Technical Note

Project No: ITB13091
Project Title: Ford Airfield – The Landings
Title: Highway Safety and Network Capacity
Ref: ITB13091-030 TN
Date: 21 July 2020

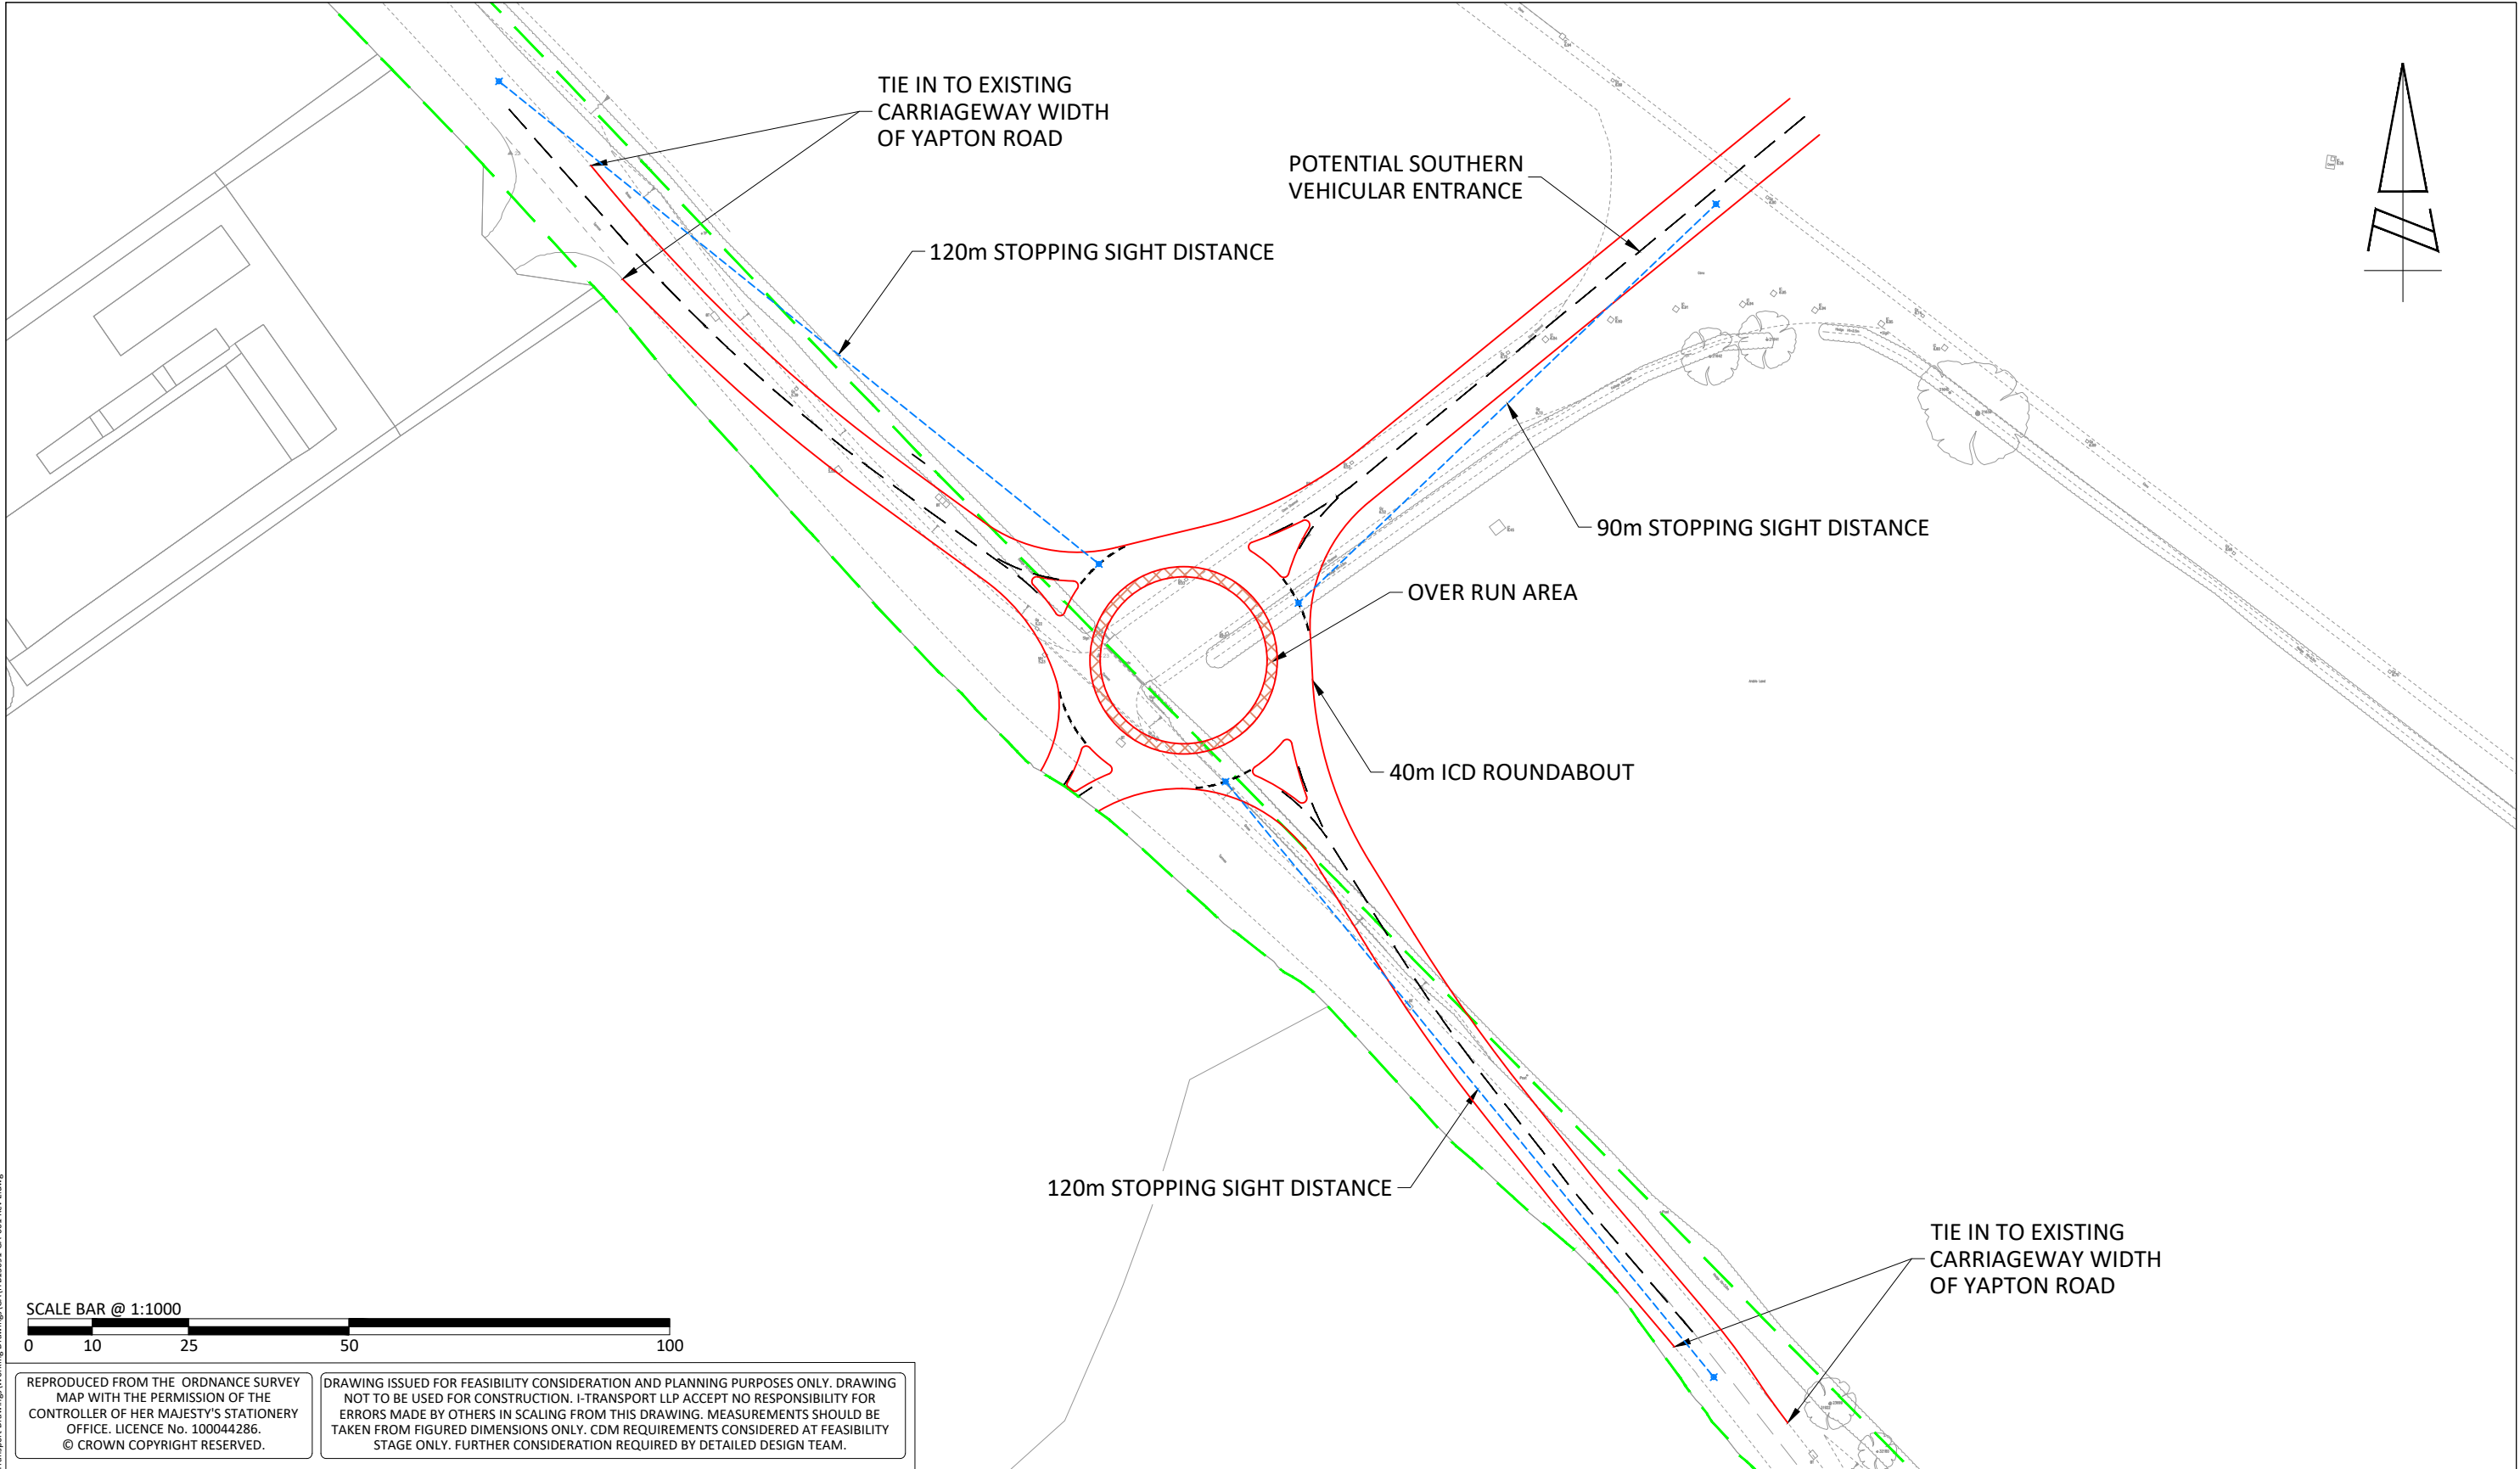
- 2.1.1 WSCC has sought clarification on the proposed site access roundabout onto Yapton Road, in particular, to confirm the dimension of the Inscribed Circle Diameter (ICD) and whether contact has been made with the landowner regarding the proposed access arrangements to the retained agricultural land west of the roundabout.

- 2.1.7 On this basis, it can be confirmed that the roundabout is to be provided as a 40m ICD 4-arm roundabout, as presented in **Drawing ITB13091-001 Rev E**, an extract of which is provided in **Image 2.1**. No further modelling of the roundabout has been undertaken, given that it has been satisfactorily demonstrated a smaller 28m ICD roundabout operates within capacity in all assessment scenarios; a larger roundabout will operate with greater capacity.

- 2.1.8 It can also be confirmed that the landowner has been consulted through the design process and is satisfied that the proposed roundabout arrangement provides suitable and appropriate access to the retained agricultural land for vehicles associated with continuation of existing operations.

T:\Project\13009 Series\1309-11TB Ford Airfield\Tech\Acad\Transport Drawings\Working Drawings\GA\ITB13091-GA-006.dwg

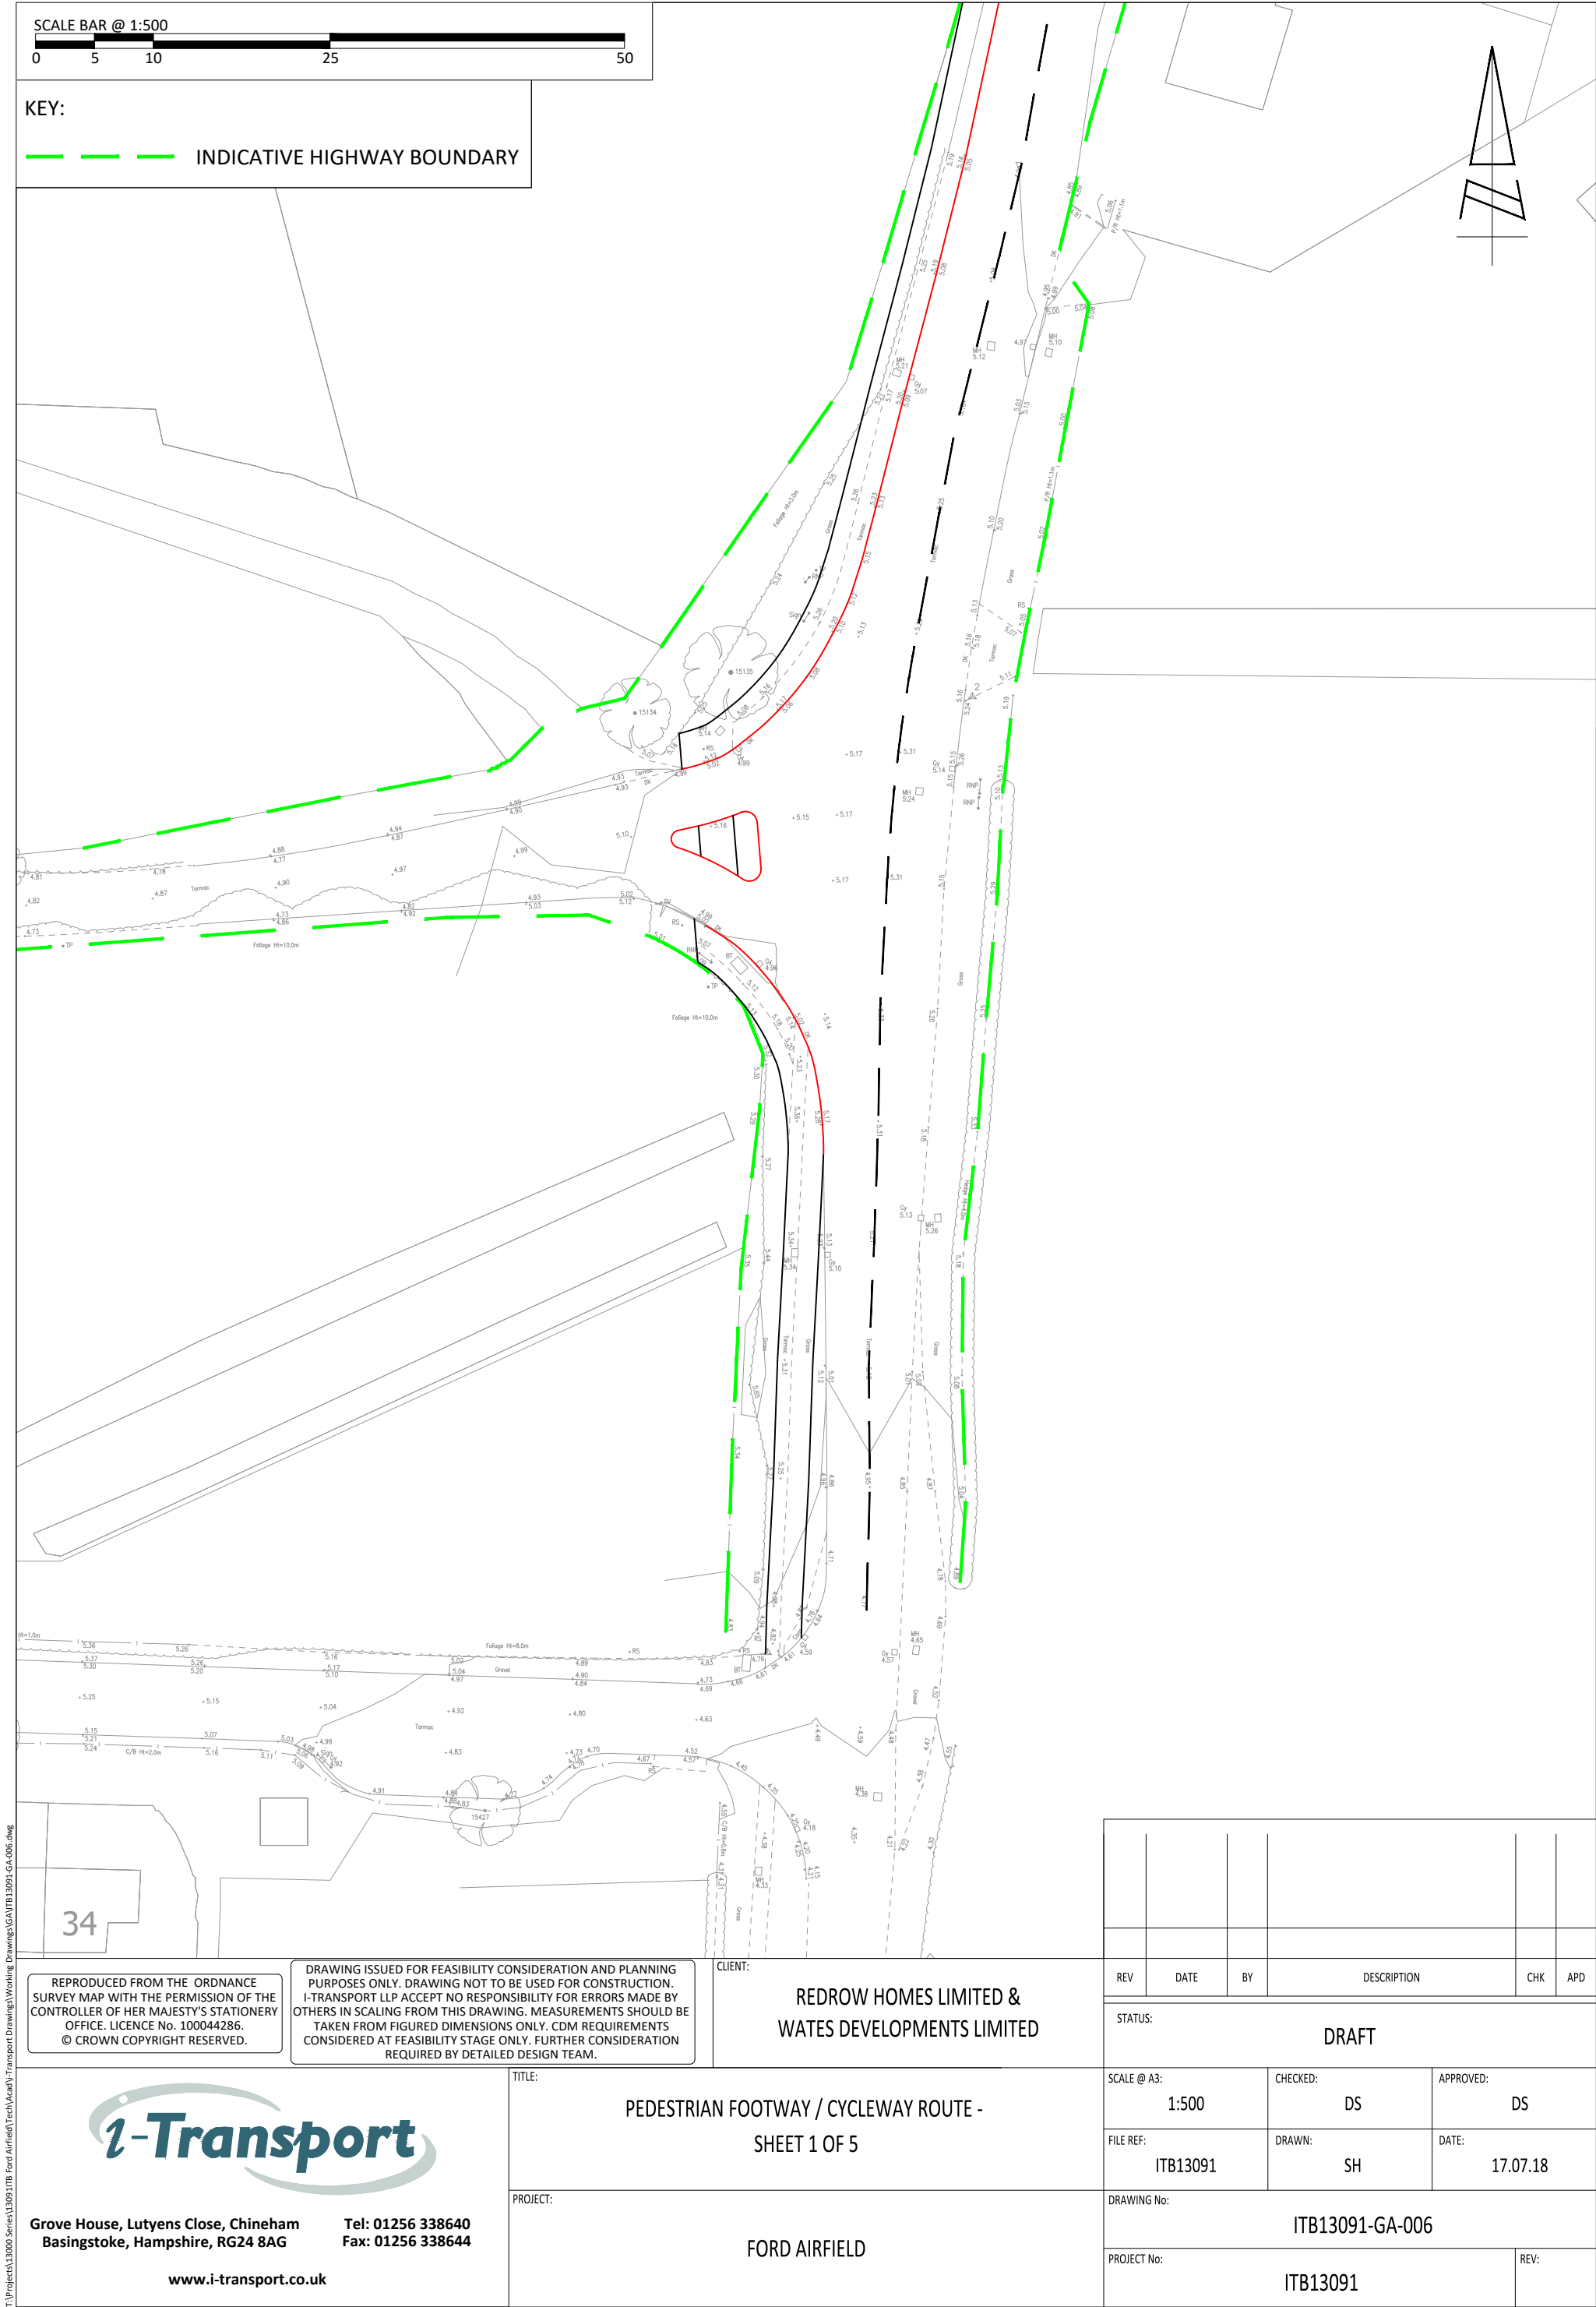
4.2.1 WSCC has requested that the modelling parameters used in the assessment of this junction be provided on a plan. The parameters are shown on **Drawing ITB13091-GA-006 Geom**.

4.2.2 The opportunity has been taken to update the junction modelling in light of the amendments to the proposed scheme of cycle improvements on Ford Road. The updated modelling outputs are presented in **Table 4.3**, with the full outputs provided at **Appendix D**.
